Date: 21 January 2026
Our ref: 27843/536681
Your ref: EN010119

Application by North Falls Offshore Wind Farm Limited (“the Applicant”) for an Order granting Development Consent for the proposed North Falls Offshore Wind Farm (“the North Falls Offshore Wind Farm Project”)

The following constitutes Natural England’s formal statutory response to the Secretary of State’s Request for Information (RFI) dated 18 December 2025. To inform this response Natural England have reviewed the following documents:

Figure 1 North Falls AOE SPA LBBG search area (including land within or in proximity to the SPA)

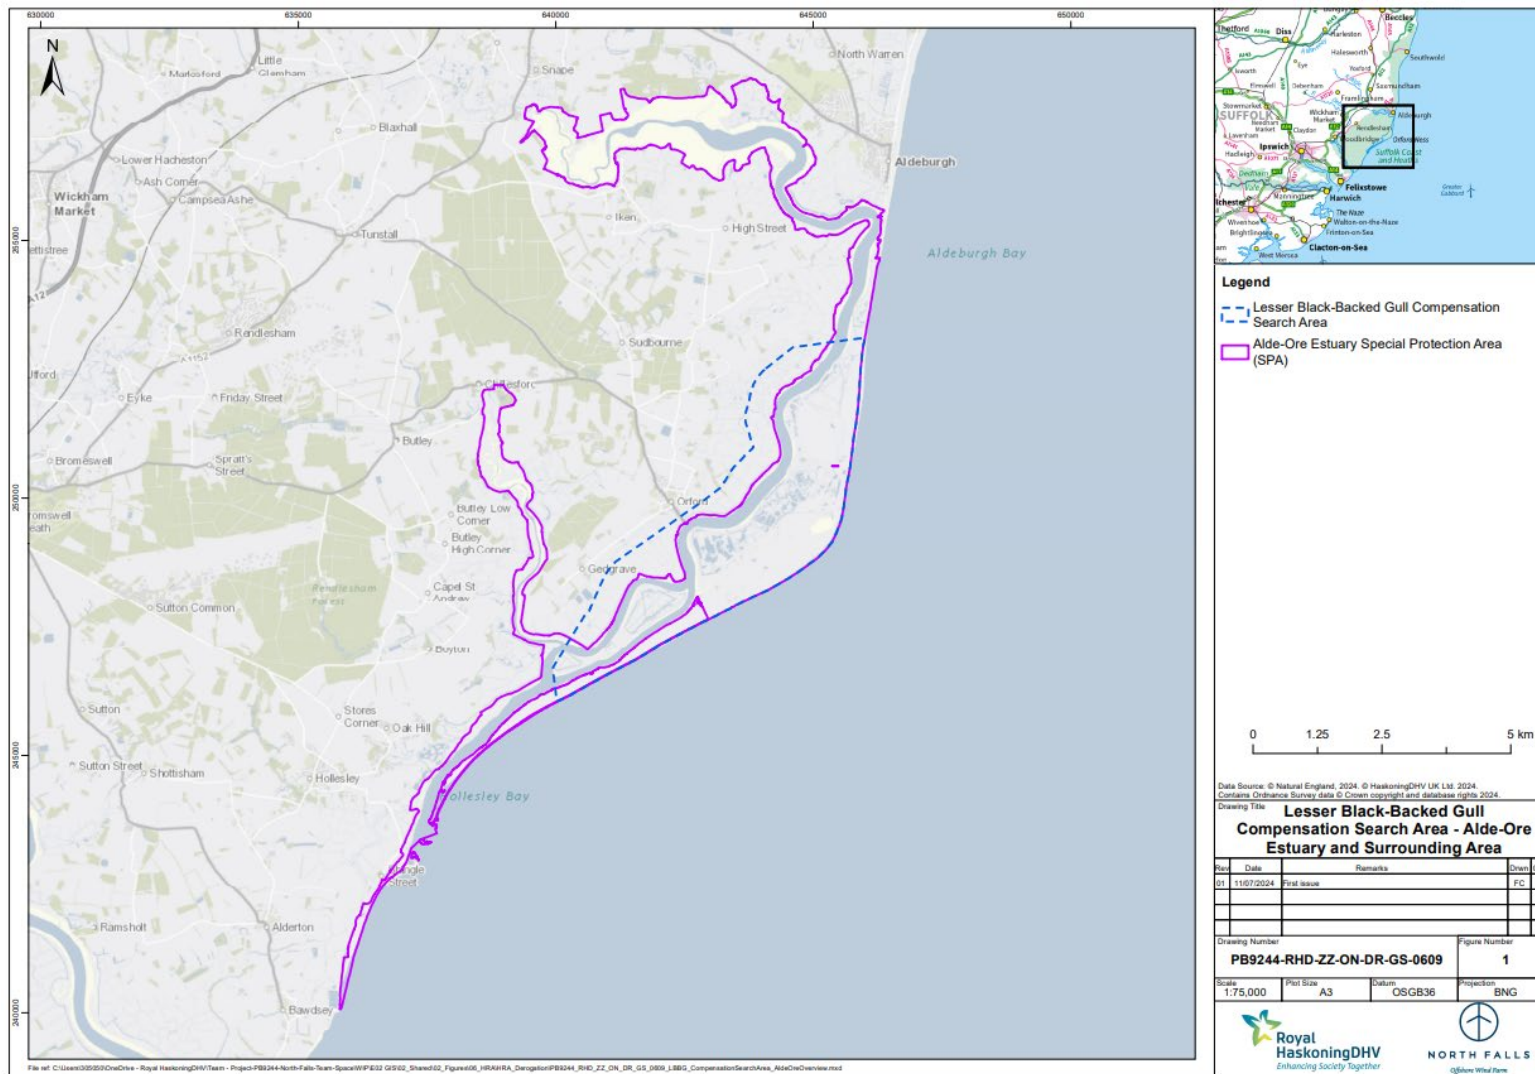
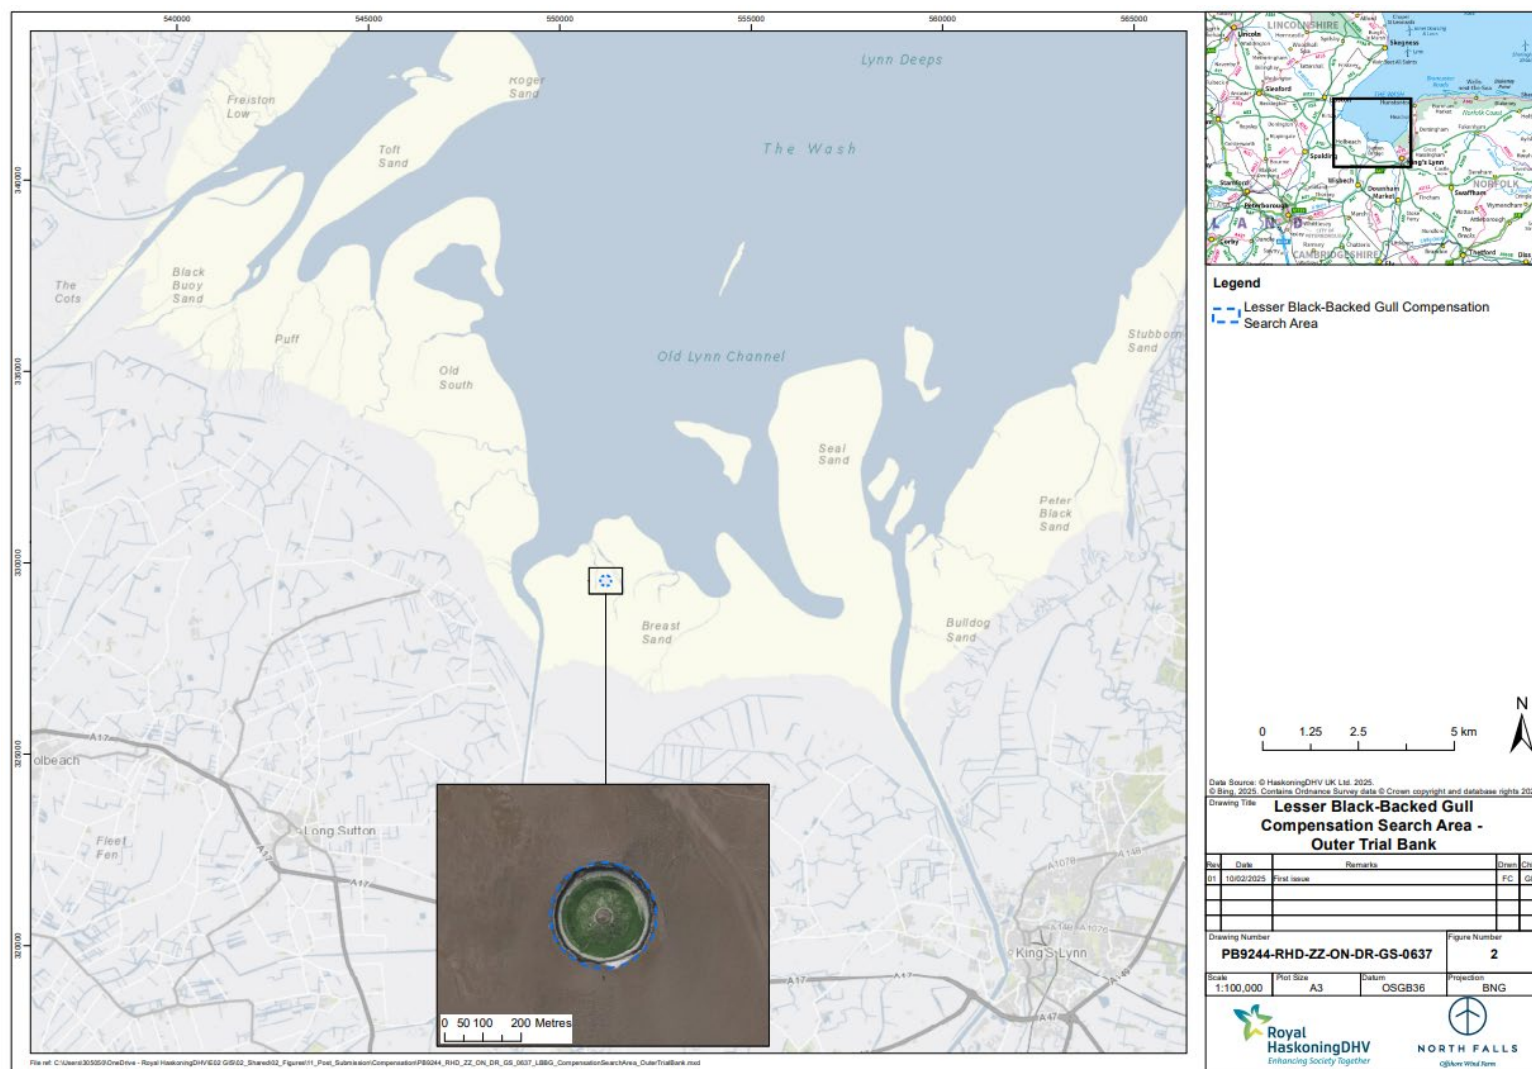
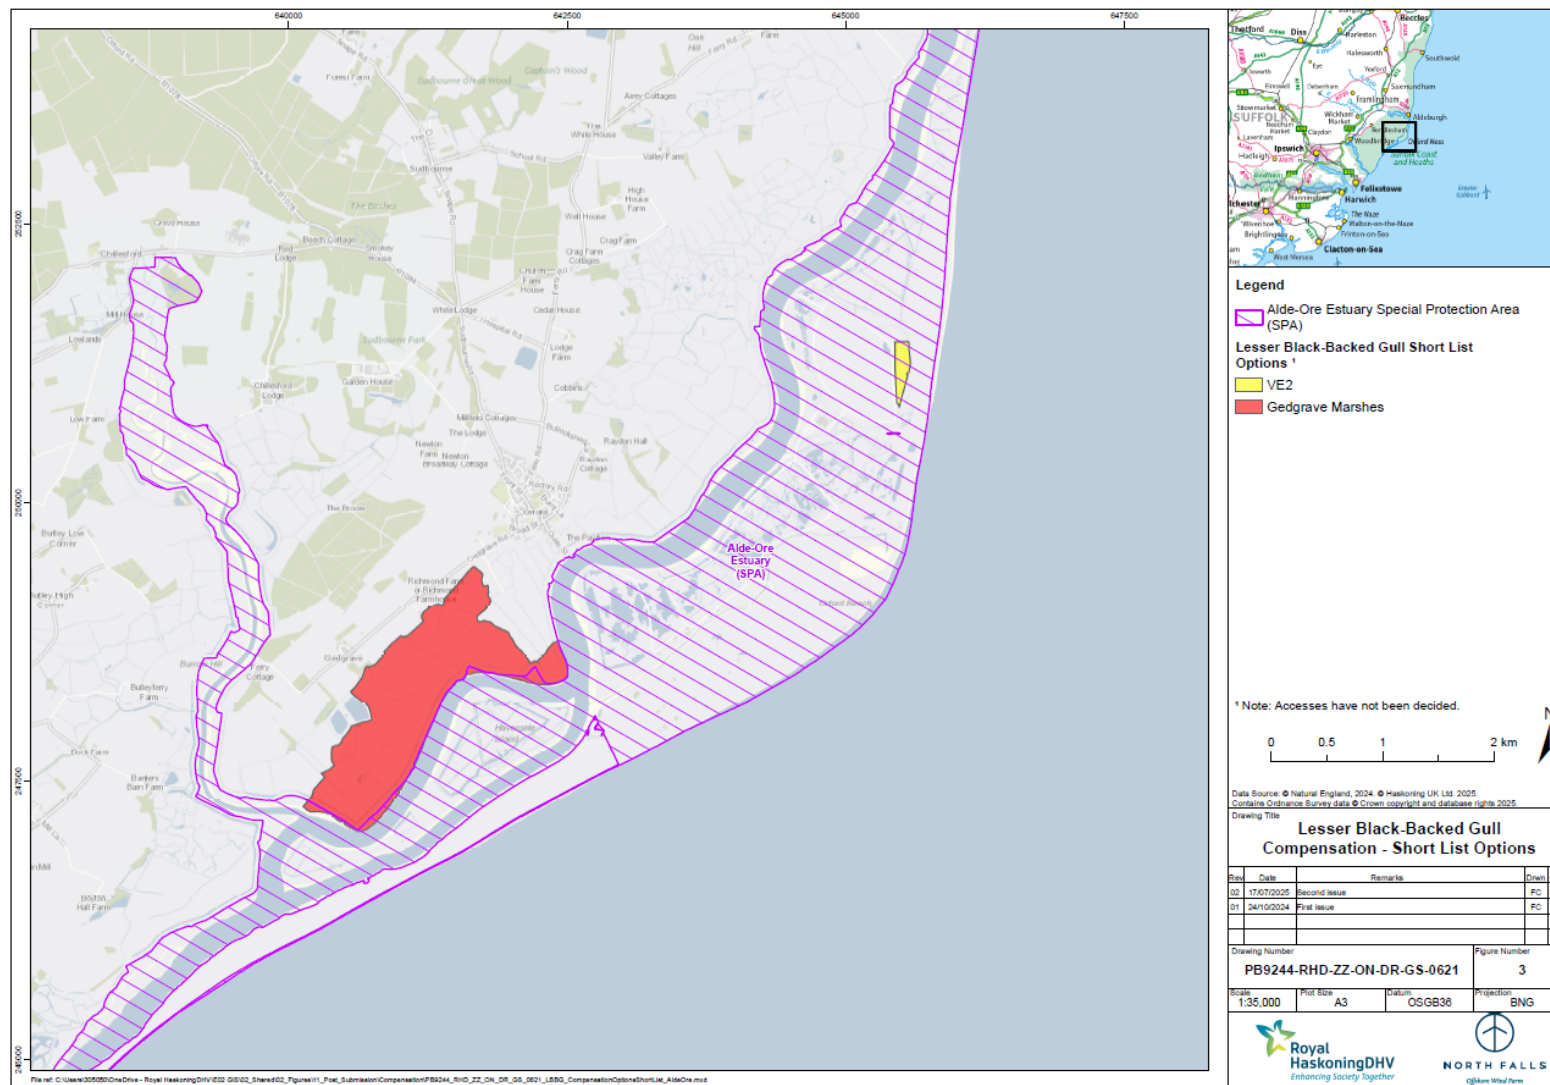
We note that the main update to the Compensation Implementation and Monitoring Plan (CIMP) is the inclusion of a new compensation area location on Orford Ness adjacent to that proposed by Five Estuaries for their lesser black-backed gull compensation (LBBG) to address impacts to the Alde-Ore Estuary Special Protection Area (SPA). This raises a new issue for consideration, as this site has not previously been assessed or taken through the Habitats Regulations Assessment (HRA) screening process.

This option is added to 'provide additionality' in the event of North Falls OWF electing to collaborate with, or deliver adaptive management through, the adjacent Five Estuaries OWF compensation proposal. Nevertheless, it remains the case that minimal information on the proposal has been presented in the CIMP. For example, there is no map of the proposed location. Surveys of the new compensation area have not been undertaken, and in their absence no qualitative assessment of the habitats present and the associated environmental risks have been made. Furthermore, the CIMP does not include any information on how the site will be accessed or any additional construction (e.g. temporary bridges, culverts) that may be required.

Therefore, there is insufficient information to support a meaningful assessment of impacts on designated sites and features. In order to take it through e.g. the HRA process. Without such information, likely significant effects (LSE) on the Orfordness – Shingle Street Special Area of Conservation cannot be excluded, and Natural England cannot determine if adverse effects on integrity (AEol) can be ruled out. Further, significant impacts on the Alde-Ore Estuary SSSI and/or Alde-Ore Estuary Ramsar site receptors cannot be excluded. We note that vegetated shingle may be present at or adjacent to the proposed site, and therefore potential habitat disturbance and changes due to the installation and maintenance of predator fencing could have significant impacts on SAC, SSSI or Ramsar site receptors.

We highlight that the existing compensatory predator fencing on Orfordness (delivered by the Norfolk and East Anglia OWF projects) has yet to yield any pairs of LBBG after three breeding seasons. This raises the risk level of too many projects being reliant on delivering compensation in the same area and as such gives greater weight to progressing either of the Gedgrave Marshes and Outer Trial Bank options included in the CIMP.
